Church Farm House, Church Road, Yapton, BN18 0EP

Application ref: Y/48/25/PL

Removal of tennis court and construction of 1No. self-build single storey energy efficient dwelling

CGS Civils Response: 21/11/2025

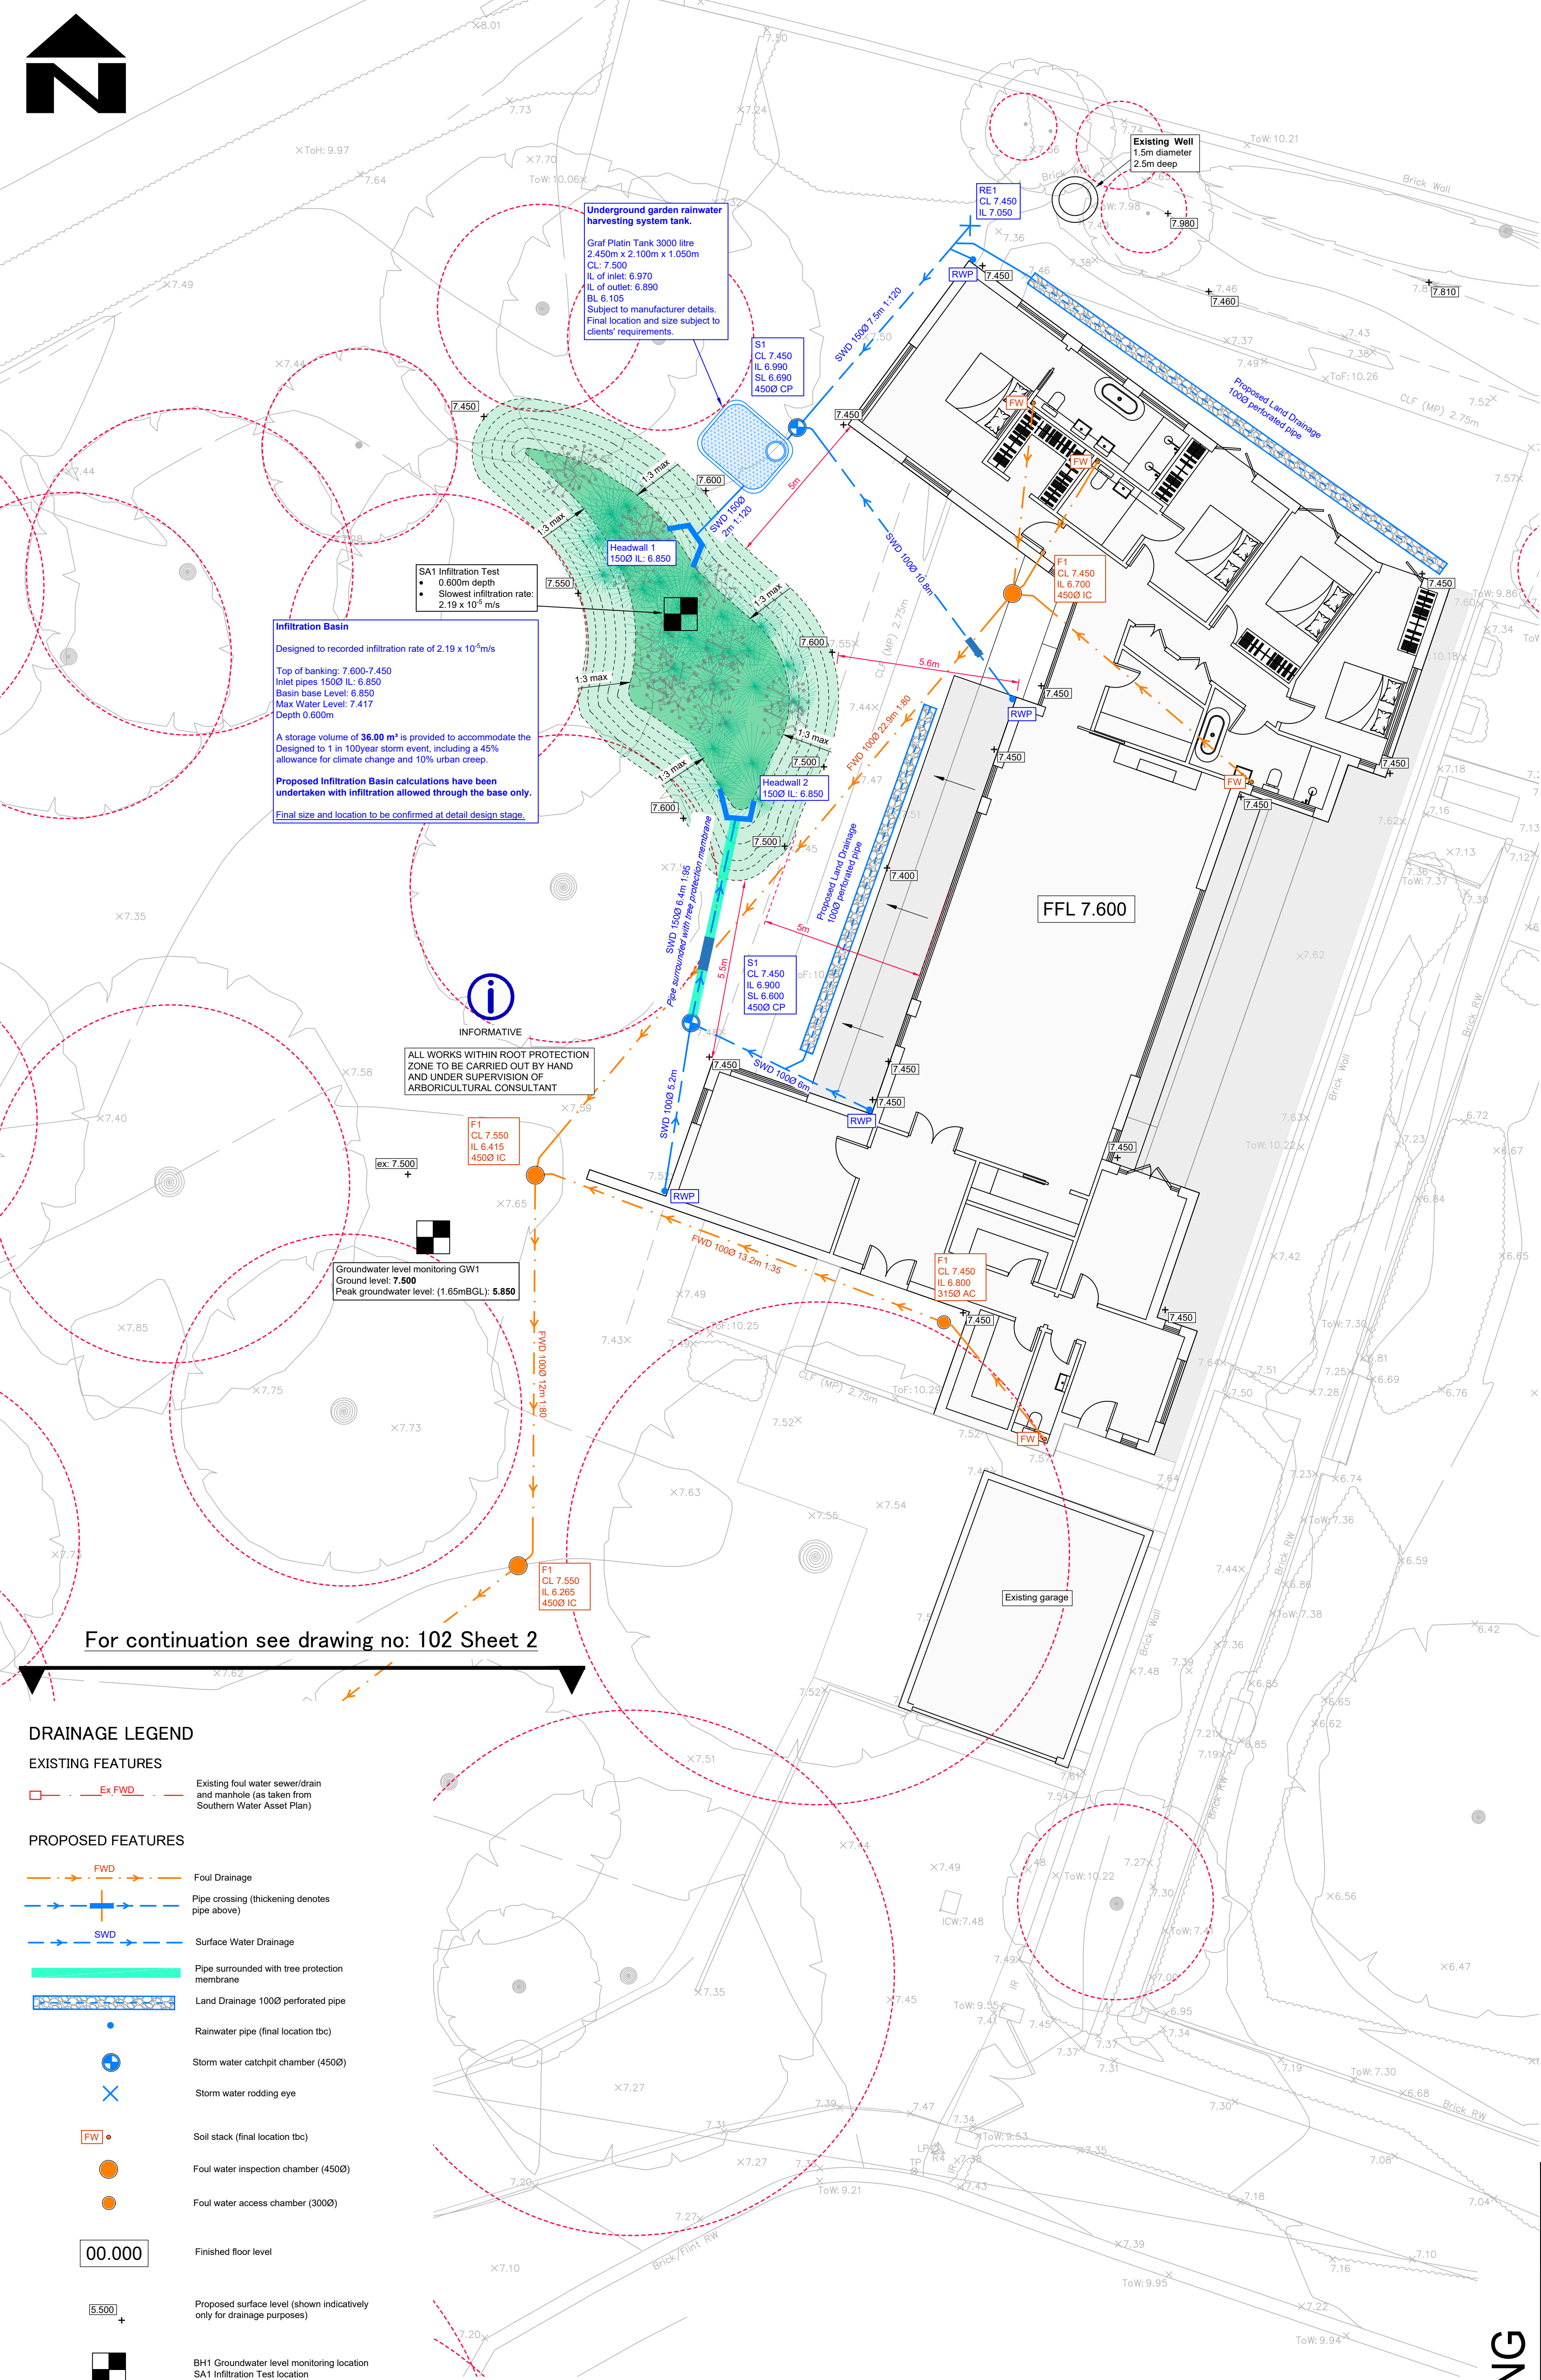
3.1 The FSWDR includes drainage plans and modelling. The simulation for the 1% AEP +45% event has a maximum water level of 7.468mAOD. This is higher than the bank at the north east extent of the infiltration basin (7.45mAOD) and the cover levels of both inspection chambers and the rodding eye. The model demonstrates that the system may flood on the 1% AEP +45% event. This may be permissible; however, such planned flooding must be demonstrated to remain on site and not flood property. The submission does not demonstrate that.

Noted. The finished floor level (FFL) of the building has been raised to 7.750 m AOD. The cover levels of the rodding eye, all inspection chambers, and the bioretention planter have been increased to 7.600 m AOD. In addition, the top of banking at the north-east extent of the infiltration basin has been raised to a minimum of 7.500 m AOD.

Following these updates, the revised hydraulic model demonstrates that during the 1% AEP (1 in 100-year) event including a 45% climate change allowance and a 10% urban creep allowance, the maximum water level within the infiltration basin is 7.439 m AOD. This level is fully contained within the basin, remaining below the top of banking and cover levels, and therefore does not pose any risk of flooding to the property or any off-site areas.

All drainage plans and storm water modelling calculations have been updated to reflect the revised design and confirm that exceedance flow routes remain within the site boundary and not flood property.

3.4 The designer has included two land drains, north and west of the proposed dwelling. These are designed to capture surface water flowing towards the proposed dwelling. This design feature is apparently included due to the need for the FFL to closely align with existing tennis court level. Where there is a need for surface water to be intercepted this should be accounted for in the design. It may be the surface water is diverted around the building without contributing to the SuDS scheme. This may be appropriate if the natural catchments are followed.

3.5 Alternatively, land drainage features can contribute to the SuDS design (as drawn). However, if they positively connect to the system then the contributing surface water volume from these features should be accounted for. This involves analysis of the contributing catchment which has not been submitted. The submitted SuDS allows an unquantified volume of surface water to be drained into the infiltration basin. This surface water volume will consume storage which is set

aside for the rainwater that falls on the new contributing area. This means that there is an increased likelihood that the basin will flood. The design must be altered to account for this volume or to manage the land drainage in alternative manner.

Noted. Following the increase in the building FFL to 7.750 m AOD, the previously proposed land drains to the north and west of the dwelling are no longer required. The updated levels now allow surface water to naturally fall away from the building toward the surrounding landscaped areas, following the natural catchment pattern without the need for interception.

As the land drains have been removed from the design, no external contributing catchment will enter the SuDS network. Consequently, no additional surface water volume will be directed into the infiltration basin, and all modelled storage requirements remain based solely on the runoff generated by the proposed development. This ensures that the infiltration basin storage capacity is not compromised and that the system does not present an increased risk of flooding.

The revised architectural plans and drainage layout confirm that surface water is safely routed away from the property, and there is no residual risk of flooding to the building.

1.4 The FSWDR includes infiltration testing completed on 26 October 2025. Record of the strata in the trial pits were not submitted. The testing was completed outside of the winter period and therefore does not accord with BRE DG 365 and may not be used for detailed design purposes. The testing provides some comfort that infiltration is likely to be viable. However, the space needed for storage may be greater than that designed due to slower infiltration potential in worse case winter conditions.

Noted. We have added a note on the drainage drawings confirming that additional infiltration testing will be undertaken during the winter period in accordance with BRE DG 365. This testing will verify whether the infiltration rate adopted in the current drainage strategy may be slower under worst-case winter conditions for detailed design purposes.
